KIRKLEES METROPOLITAN COUNCIL INVESTMENT & REGENERATION SERVICE

DELEGATED DECISION TO DETERMINE PLANNING APPLICATIONS

Reference No:	2023/62/93292/W
Site Address:	26, Wyverne Road, Golcar, Huddersfield, HD7 4BY
Description:	Demolition of conservatory and garage and erection of single storey rear and side extension and carport canopy
Recommending Officer:	Joanna Rednall

DECISION – CONDITIONAL FULL PERMISSION

client	MR & MRS BROOK		
project	PROPOSED EXTENSION TO 26 WYVERNE ROAD GOLCAR HUDDERSFIELD HD7 4BY		
drawing	PROPOSED PLANS AND ELEVATIONS		
revision	notes	date	drawn
A	PLANNING REVISIONS	16.01.24	PB
scale :	1:50 AND 1:100 AT A1	09.23	PB
project no.	drawing no.	revision	
2145	02	A

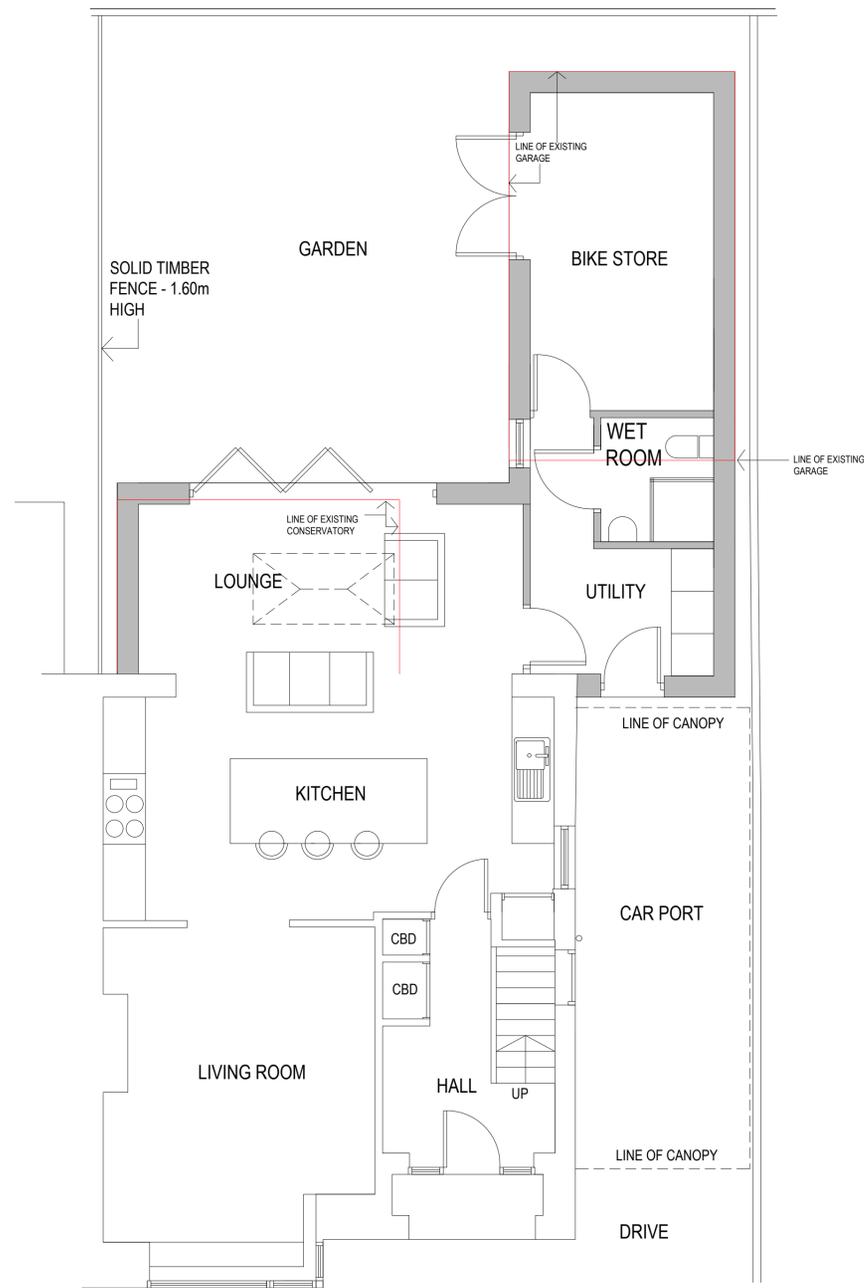
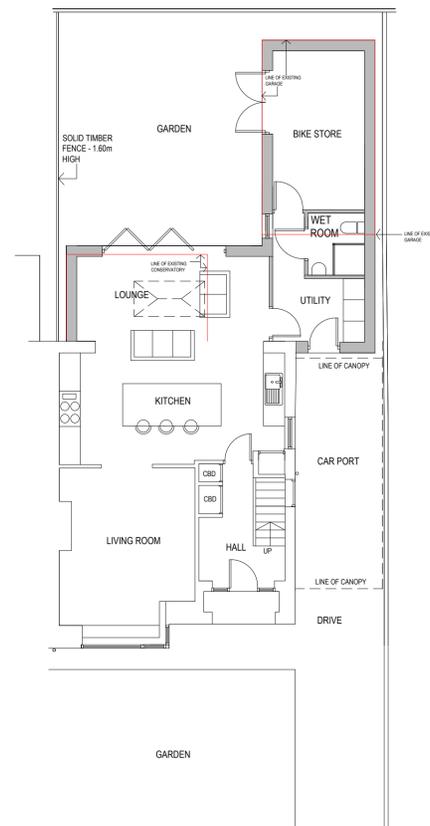
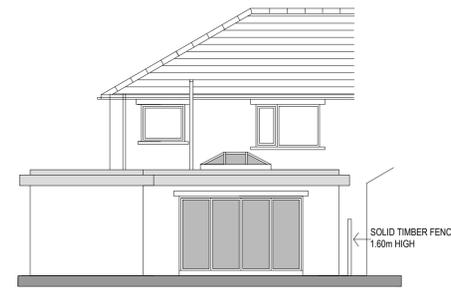
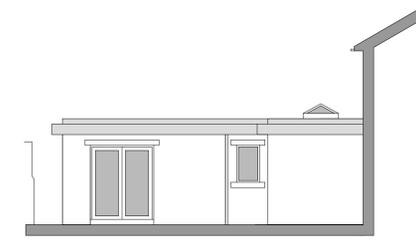
Multiple discussions have been held with the agent regarding the size of the proposal and the impact on neighbouring properties. Final amended plans were sought and provided which reduce the rear projection to no greater than the existing garage. Justification for the scheme, in terms of the width of the side extension, was provided and raised the following points:

In terms of the side extension, a 1 metre gap from the property boundary would not be retained. The proposed works would retain ~0.2 metres on the east-facing boundary and ~0.3 metres on the west-facing boundary. The proposed design has been justified by the agent as it would be the same width as the existing garage and the two extensions would '*link built forms where the massing already exists*'. In this case, as the width of the garage would not change as a result of the development, the boundary gap is considered acceptable. In addition, while a ~0.8 metre gap would be retained between the rear elevation and the rear boundary of the site, this is considered acceptable as it would follow the footprint of the existing garage.

The width of the proposed side extension would be ~1.6 metres which is considered to be acceptable. The proposed works would not exceed a height of 4 metres and it would be set back at least 500mm from the original building line. In terms of the carport canopy, the width would be less than two thirds of the width of the original house and it would not exceed a height of 4 metres. It would be set back ~1 metre from the original building line and would therefore comply with the parameters above.

This dwelling is adjoined to No 26 on the west-facing elevation. The proposed rear extension would project ~0.2 metres further than the rear conservatory at this neighbour. This neighbour would not have their privacy significantly impacted due to there being no windows within the side elevation. In addition, given the projection would increase by 0.2 metres, it is not considered to cause undue overlook or overshadowing on the rear amenity space. Weight is afforded to the fact that a single storey rear extension could be undertaken in any event by utilising pd rights and this would be a realistic fallback of the proposed works.

Regarding the rear extension, it would be sited ~ 2.5 metres from the shared boundary with blank elevation which is acceptable in terms of privacy and overbearing.

- The extension would be the same width as the existing garage.
- The proposal would link the built forms where massing already exists.
